Application number: 2024/90923	
What is the application for?:	Demolition of existing conservatory and erection of single storey side extension
Address of the site or building:	Kelvin Villa, 1, Newsome Street, Dewsbury, WF13 4HE
Postcode:	WF13 4HE

User comments

PROPOSED FRONT ELEVATION
1:100 @ A1

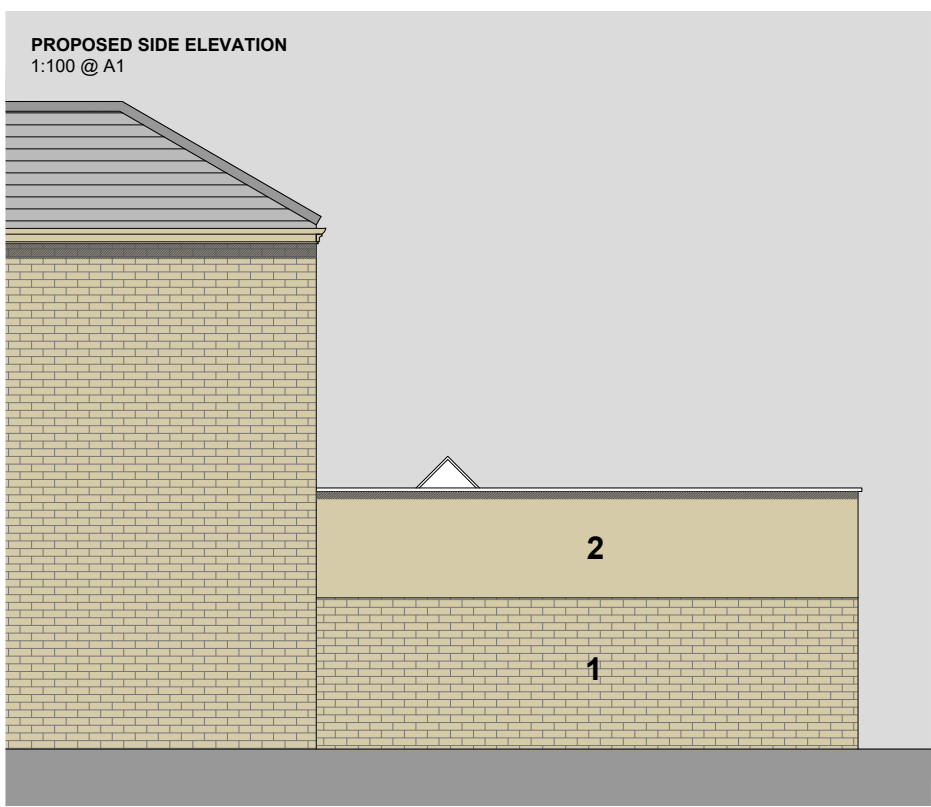
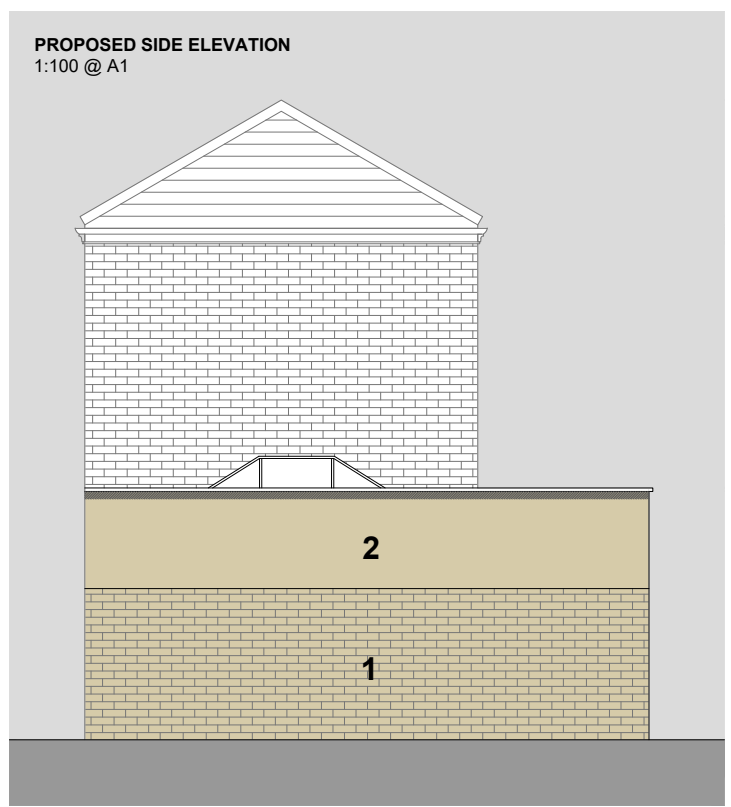
Type of comment: An objection	
Do you wish your comments to be published on the website anonymously?	<input type="checkbox"/> Yes
<p>This extension was done without planning permission which the Planning Inspectorate ruled in the council favour which has to be fully demolished by the 8th January 2025. This proposed single storey extension should be rejected due to height, roof design and use of rendering which will result in incongruous development. The front elevation comes way pass the property so will be out of character with the main house. This development will neither preserves nor enhance the character and appearance of the conservation area due to the height, flat roof design and rendering.</p> <p>FACT- The height is way too high it's never been this high FACT- Never had a flat roof FACT- Rendering will make the area look ugly FACT- Front elevation comes out too much</p>
